DECISION DELEGATED TO HEAD OF PLANNING

Application No:	H14-0020-24	Applicant:	Ashwood Homes Ltd
Proposal:	Details of site levels & floor levels, construction management plan & method statement, estate road phasing & completion plan, adoptable estate roads & footways, surface water drainage scheme, on-site foul water drainage works, cycle store, acoustic barrier, landscaping & tree planting, boundary treatments, management plan for areas of publicly accessible open space & outdoor play areas, management & maintenance schedule, additional elevational treatments for plots 1, 2, 11, 67, 68 & 69, external boxes for gas & electricity supplies, gas flues & soil vent pipes, preliminary ecological appraisal, swift next bricks, biodiversity management plan, local area for play (LAP) & water consumption (Conditions 3, 8, 9, 10, 11, 12, 13, 14, 15, 16, 17, 18, 19, 20, 21, 22, 23, 24 & 25 of H14-1218-21)		
Location:	The Yews Farm Land Off Spalding Road Pinchbeck

This application is for a discharge of conditions 3, 8, 9, 10, 11, 12, 13, 14, 15, 16, 17, 18, 19, 20, 21, 22, 23, 24, 25 application relating to Planning Permission H14-1218-21.

Landscape Proposals

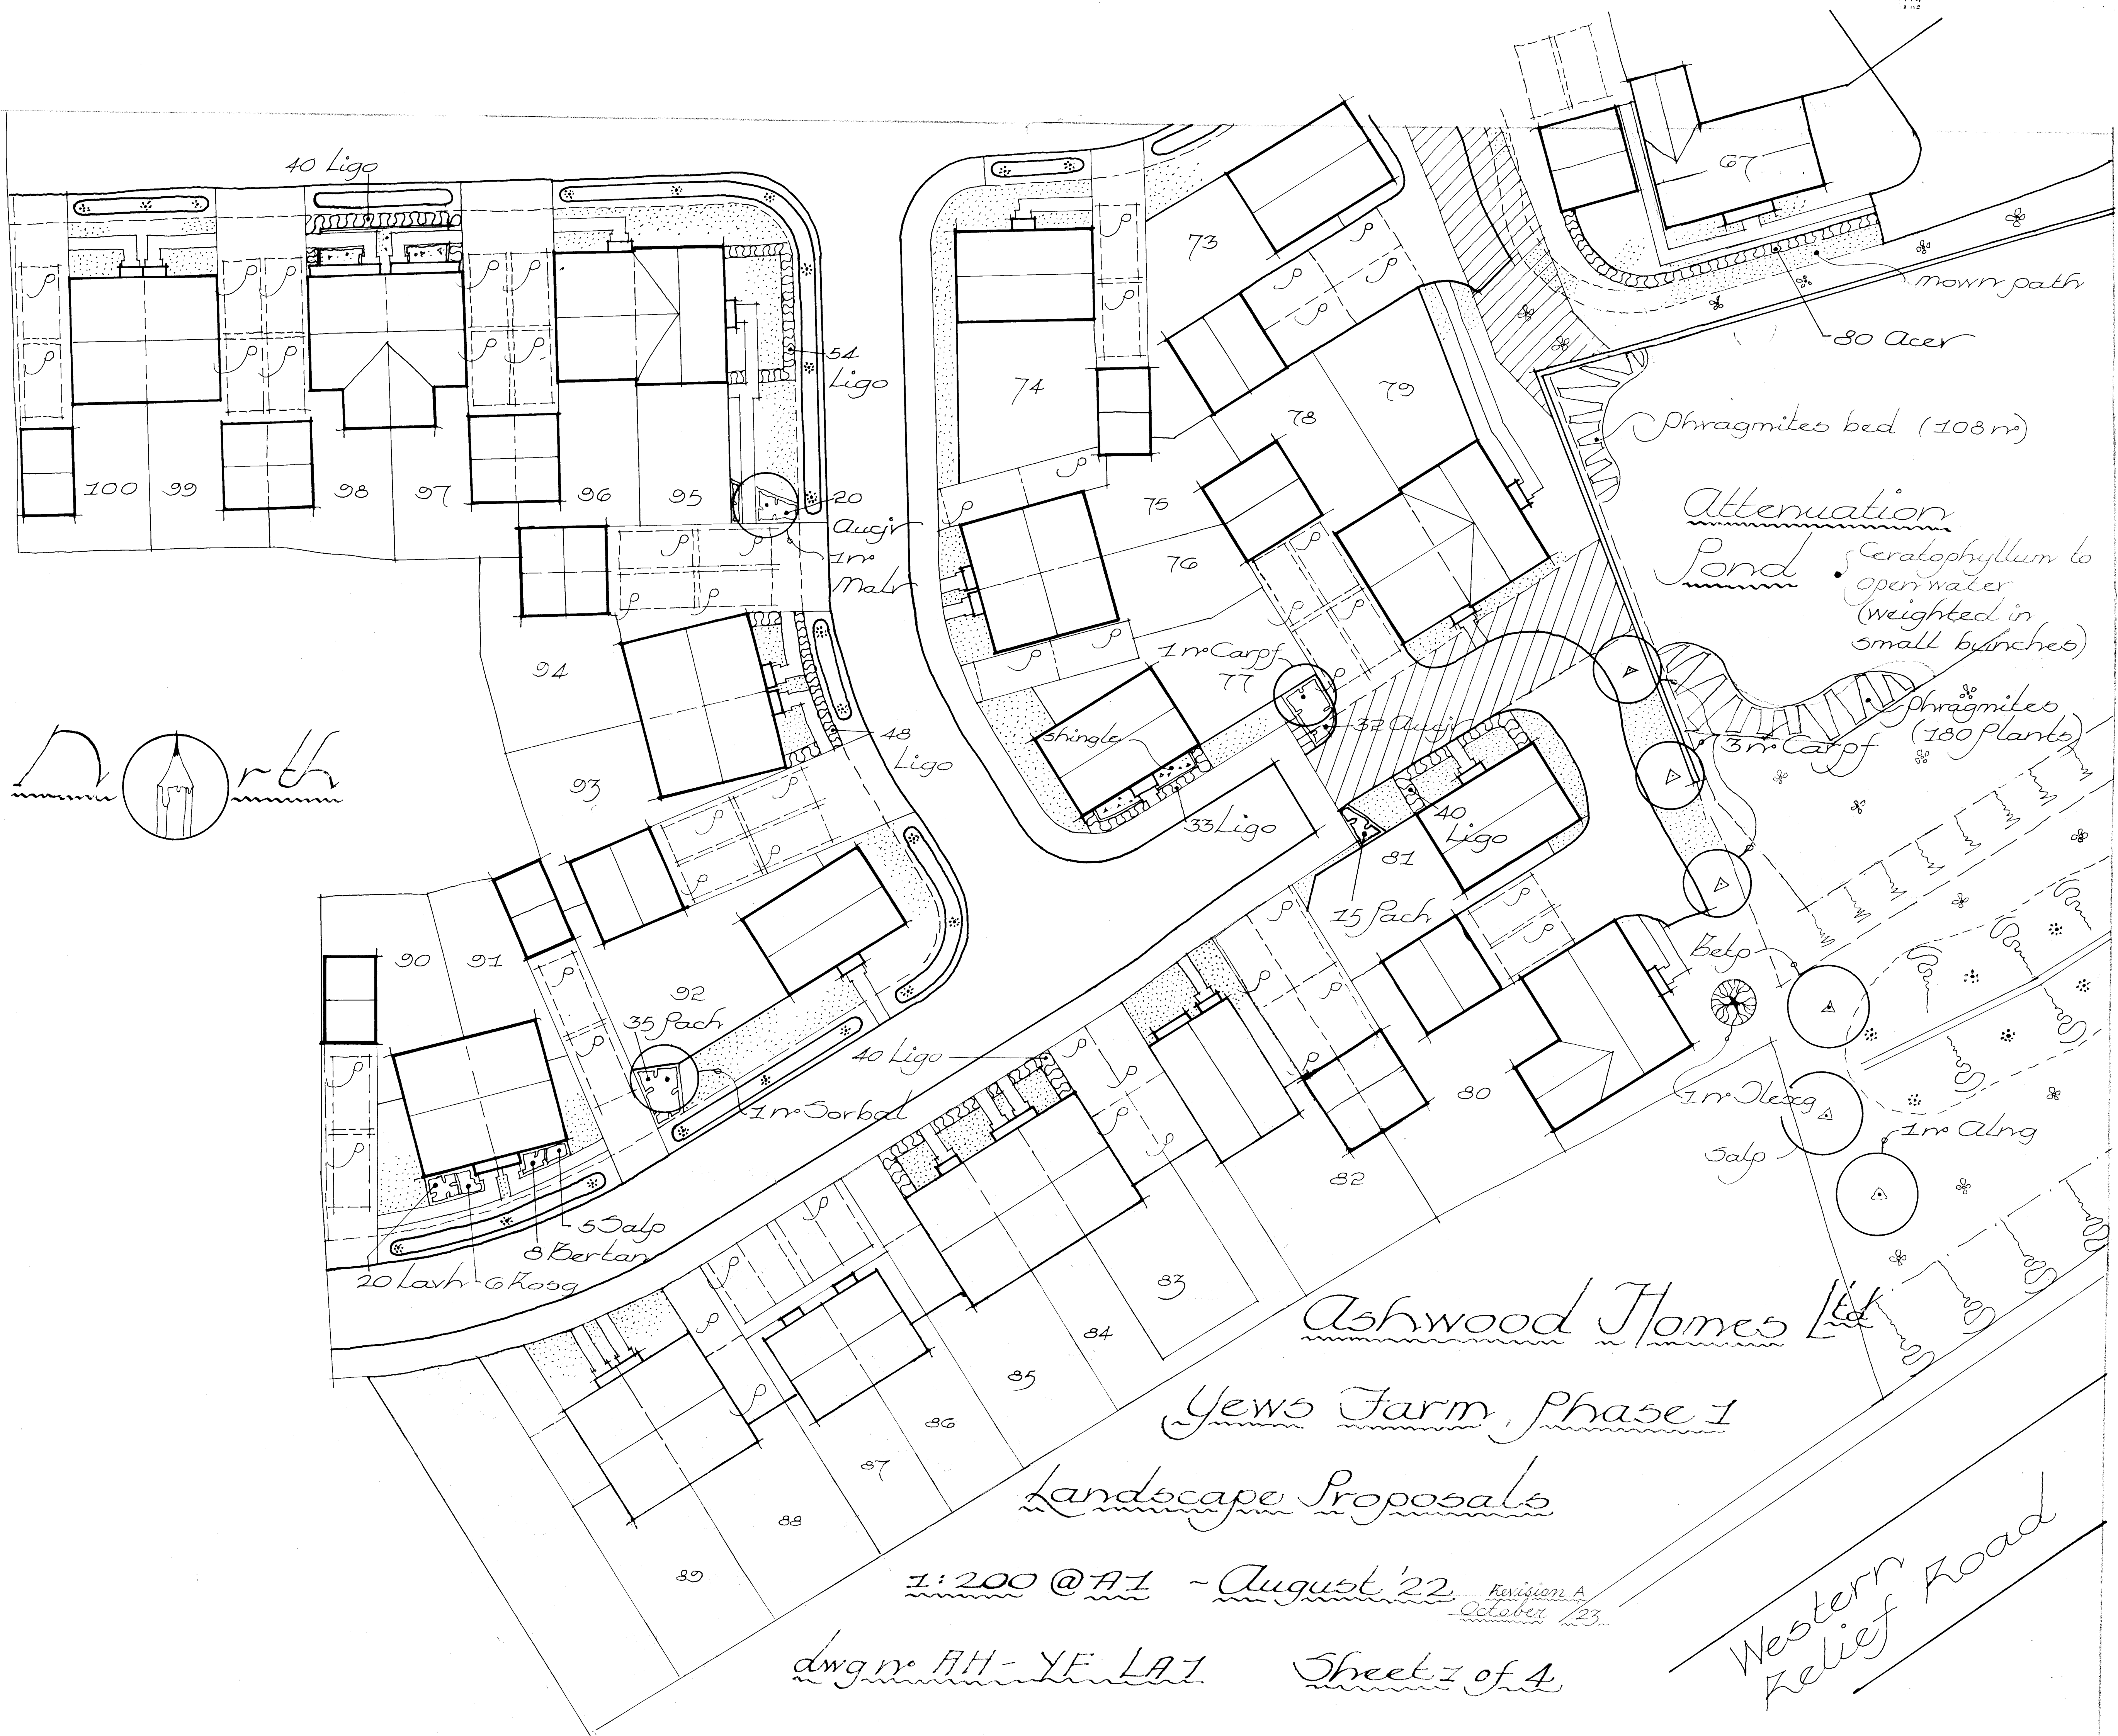
The applicant has provided landscaping plans, maintenance schedules. Lincolnshire Wildlife Trust have made comments that Net Gain calculation using the Defra Biodiversity Metric 4.0 has not been provided and so the scheme is unacceptable as a net gain is not demonstrated. It should be noted that a net gain in this instance is required by policy and is not mandatory, nor is the submission of a metric in this instance. Given the features including the pond and planting the proposed landscaping scheme is considered acceptable.
